**From:** Melissa Rassack  
**Sent:** Wednesday, 17 November 2021 10:52 AM  
**To:** William Hodgkinson; Rebecka Groth  
**Cc:** Jane Grose  
**Subject:** RE: Notice of Exhibition – Access Logistics Park (SSD-17647189)

- DCP – The Department is close to finalising the Mamre Road Precinct DCP. The SSDA should comply with the DCP once finalised.
- Setbacks – Setbacks should be consistent with the Mamre Road Precinct DCP and be measured from the new boundary (post road widening of Mamre Road).

11213_DA011

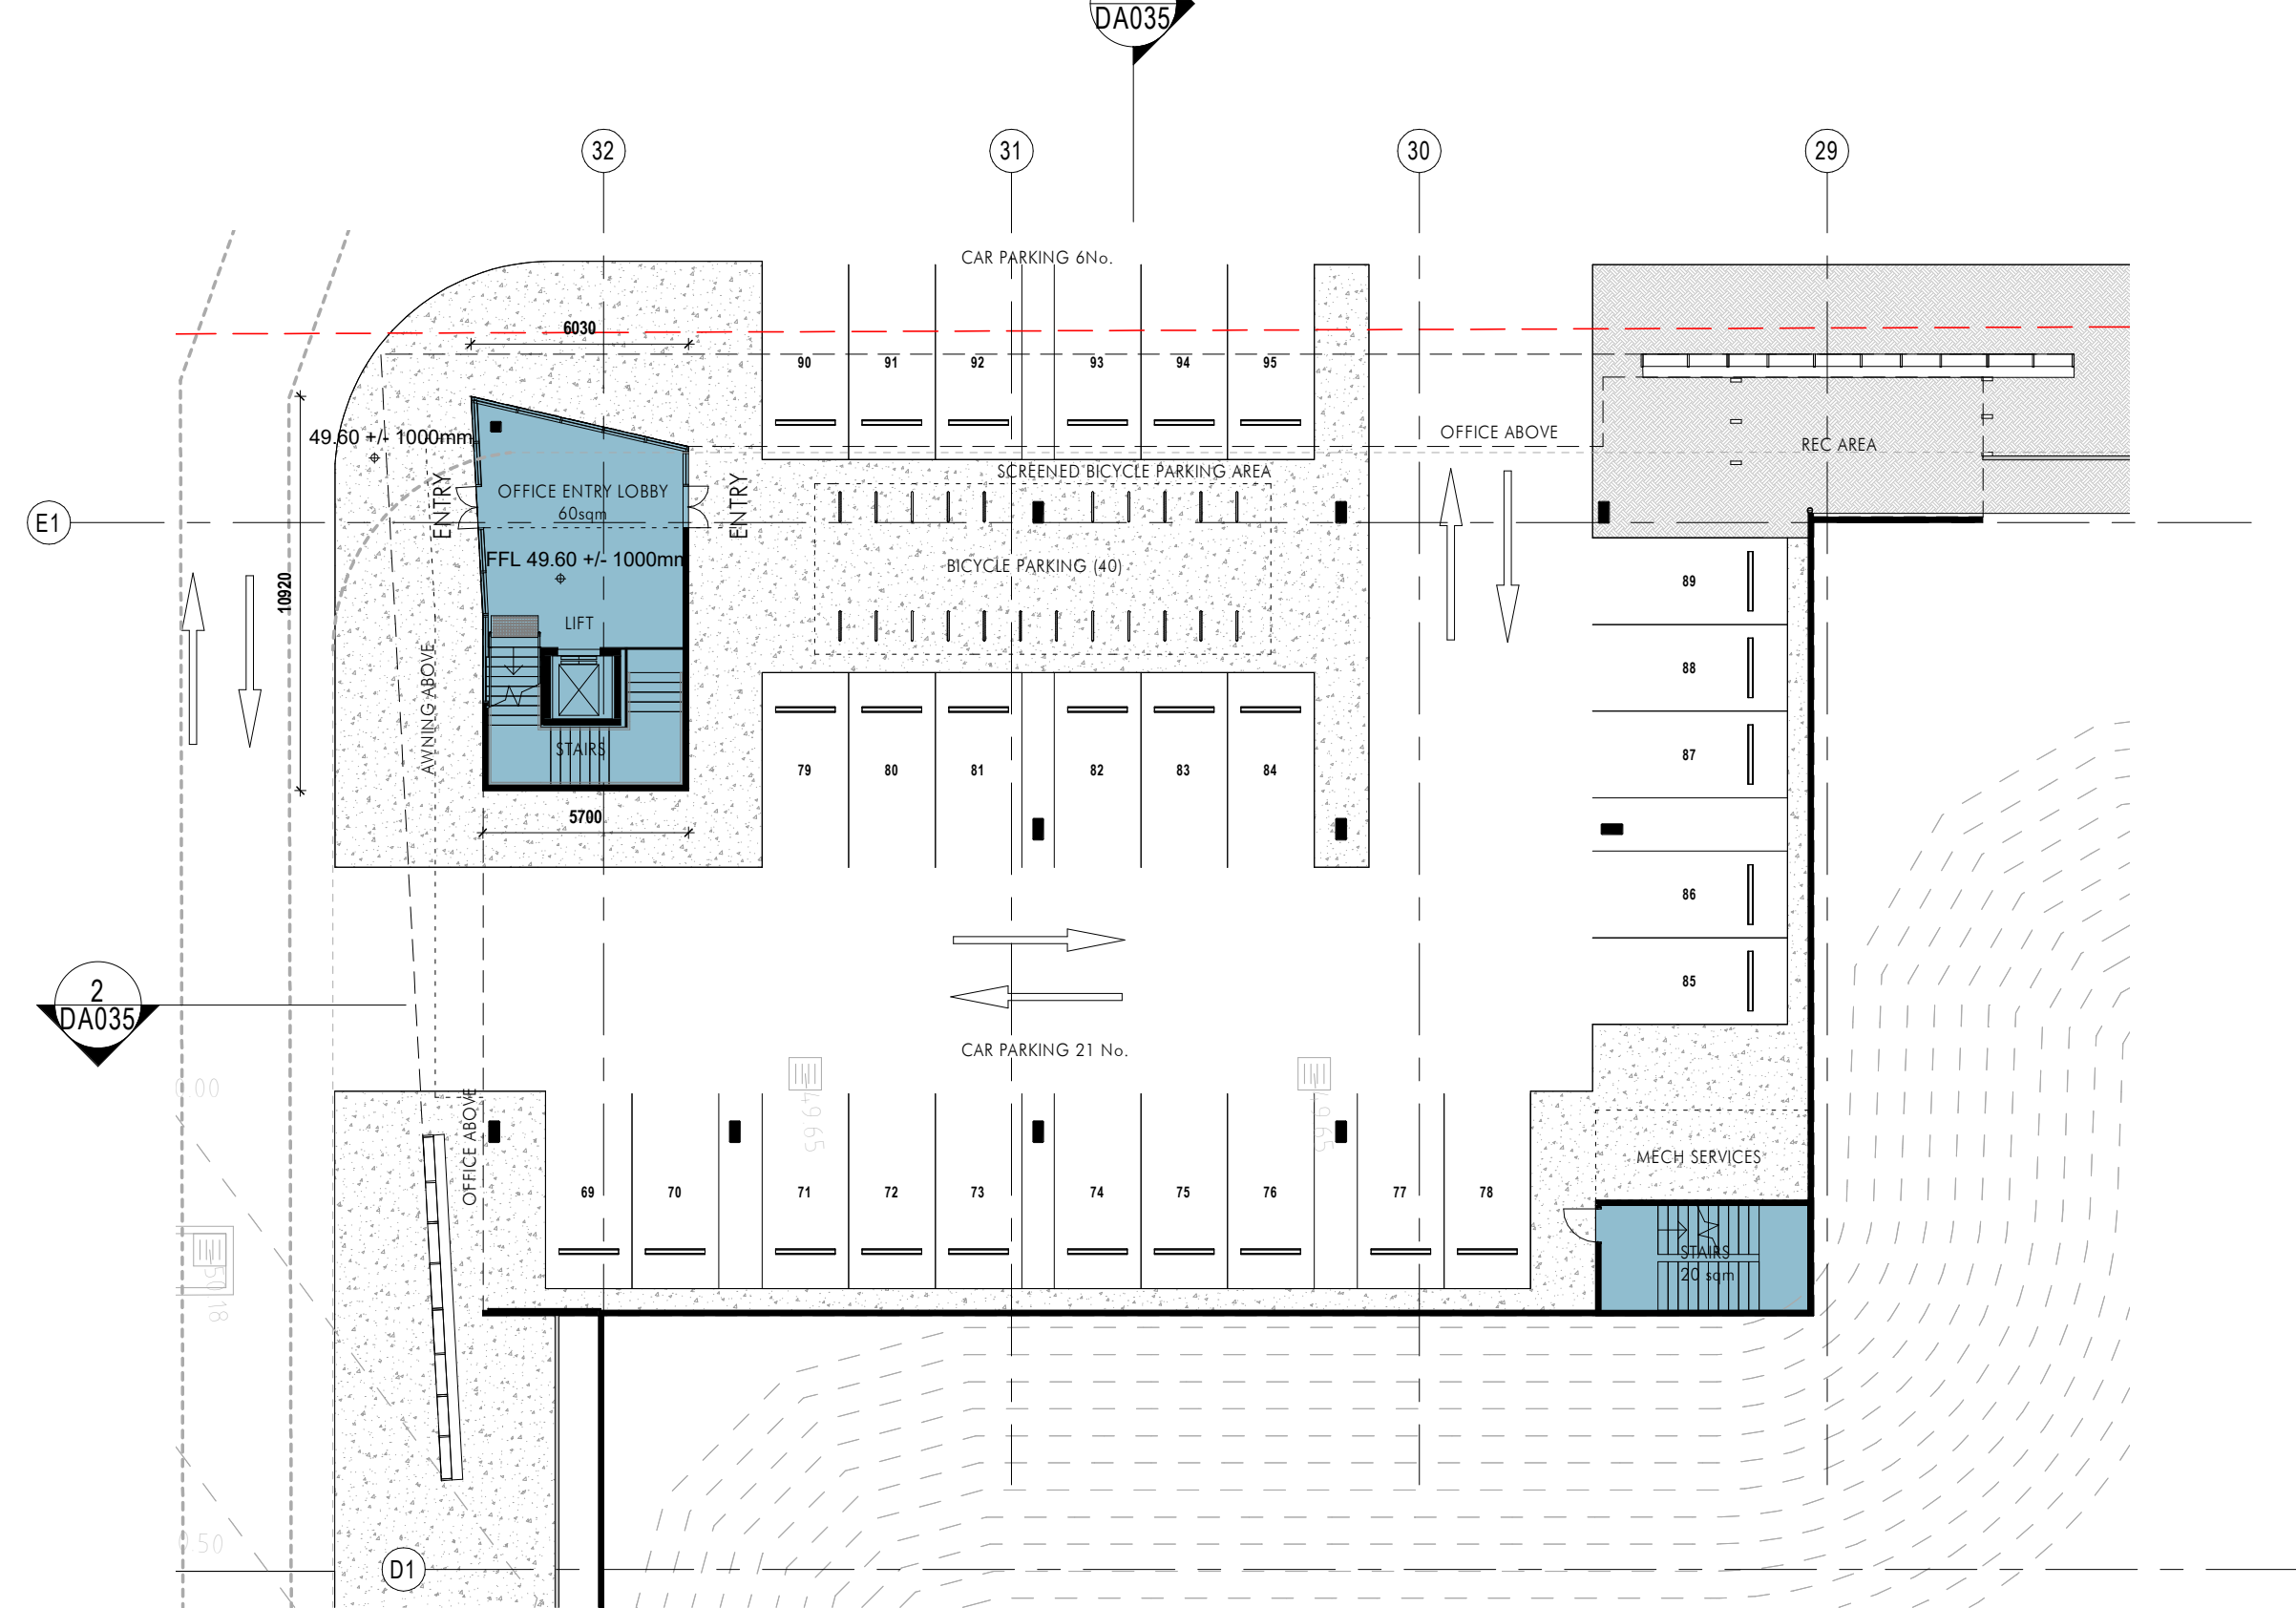
- Pervious surfaces – The submitted Landscape Design Report identifies that Lot 2 achieves a pervious area of 6.4% plus within parking areas. The development must demonstrate compliance with the minimum 15% per lot (excluding streets) pervious surface development control within the draft Mamre Road Precinct DCP.

- Tree Canopy – Confirmation of percentage of tree canopy is sought (excluding street trees). A target of minimum 10% tree canopy on development lot should be achieved.

- Earthworks – It must be ensured that earthworks must meet the requirements of cl. 33H and 33L of the WSEA SEPP, including the effect of the proposed development on the exiting and likely amenity of adjoining properties. Retaining walls adjoining the public domain greater than 2m should be stepped with suitable landscaping, with a maximum retaining wall height of 6m.
